From: [REDACTED]
Sent: 12 April 2022 09:23
To: 'David Jukes'; 'Tim Townsend'; [REDACTED]
Cc: Simon Davis; 'Nigel Jarvis'; Steven Shaw
Subject: RE: 2087 - Woodgate - Final comments and RSA sign off query.

Further to the following, I am satisfied the revised layout shown on drawings 2087 36F addresses the issue of carriageway widths adjacent to the traffic islands. I will liaise with Tim on his return to the office to ensure Item 2.3 of the first RSA and Item 2.4 of the second RSA have appropriate RSA Actions recorded within the RSA Response Reports given the layout changes made.

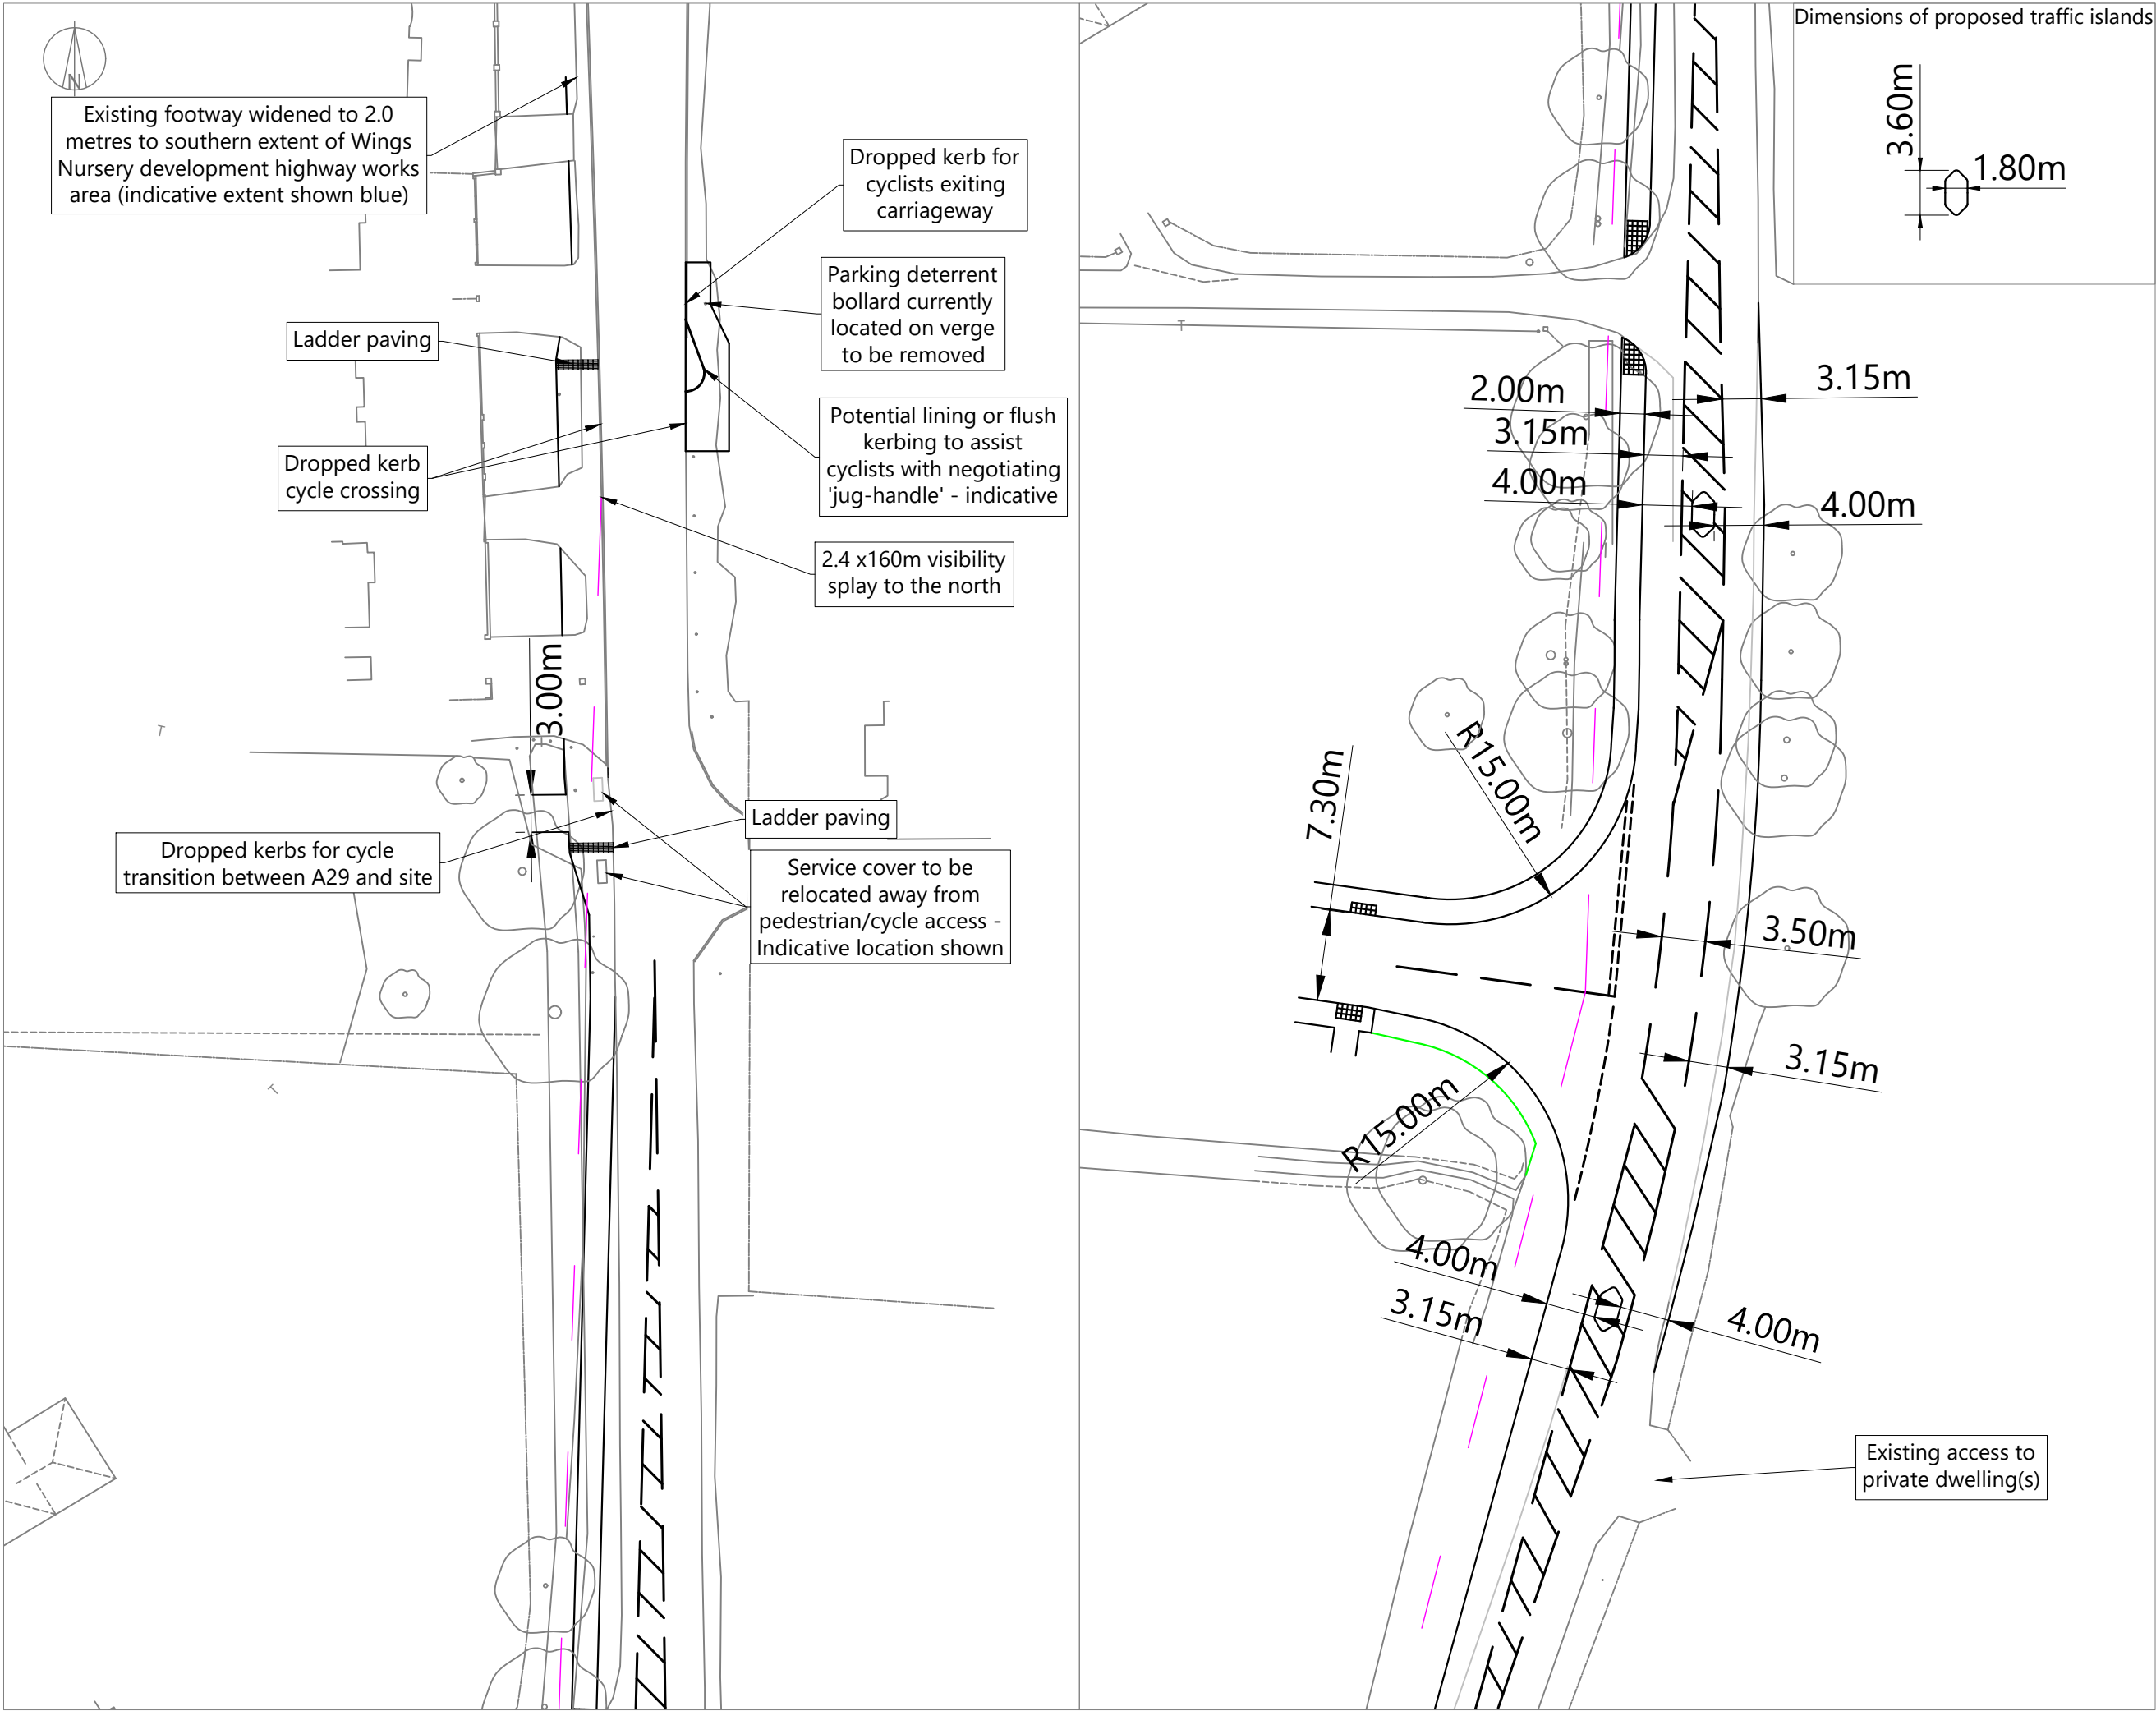
Having looked at the various details alongside DMRB, my view is that the design now demonstrates the appropriate kerb-to-kerb widths. These will be checked again at detailed design stage (S278) should planning permission be granted for the proposal. All I would add at this stage is that I have not been able to discuss this with David Jukes as he is unavailable today and I do need to know he is happy from the Road Safety Audit viewpoint.
